PLAT OF
VISTA OAKLAND
 SITUATE WITHIN
**PROJECTED SECTION 18
 T.11N., R.4E., N.M.P.M.
 ELENA GALLEGOS LAND GRANT
 CITY OF ALBUQUERQUE
 BERNALILLO COUNTY, NEW MEXICO**
 OCTOBER 2013

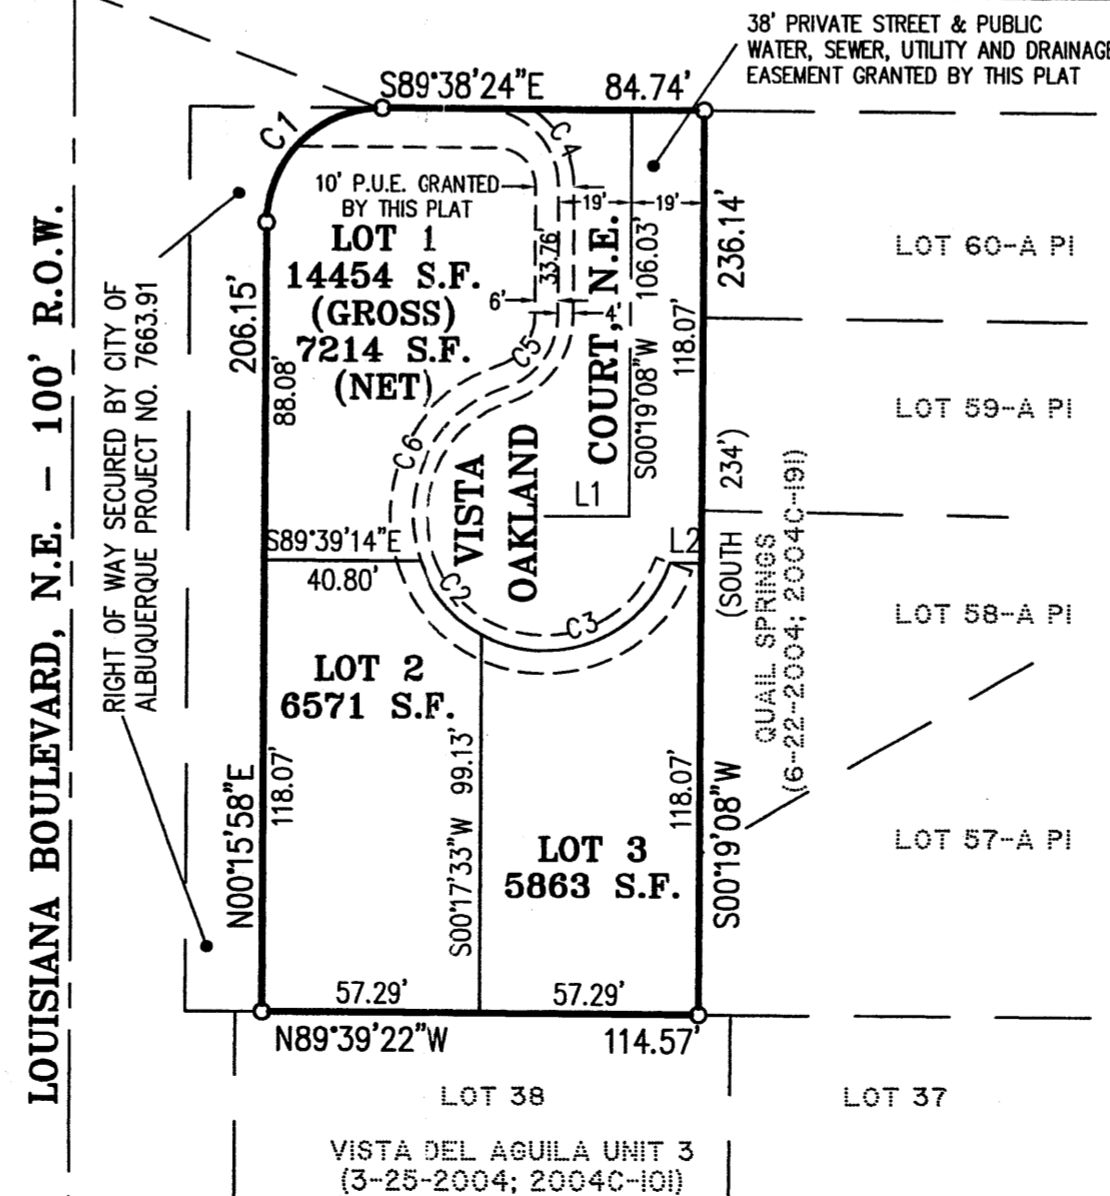
Define amount of right of way to be dedicated (in square feet).

Define maintenance responsibilities for easements.

Unless right of way was secured by the City for Oakland Ave, the original North Albuquerque Acre lot extended to the middle of the street and this 'easement' area would need to be dedicated with this plat.

The beneficiaries of the private access easement need to be clearly called out on the plat; consistent language should be used on the plat drawing, i.e. private <u>access</u> not private <u>street</u> easement.

The site is zoned RD and is within the La Cueva Sector Development Plan – refer to the sector plan for development regulations. Refer to comments from Transportation Development regarding proposed street layout. The Private Access Easement would need to include Public Water and Public Sewer Easements, granted to ABCWUA.
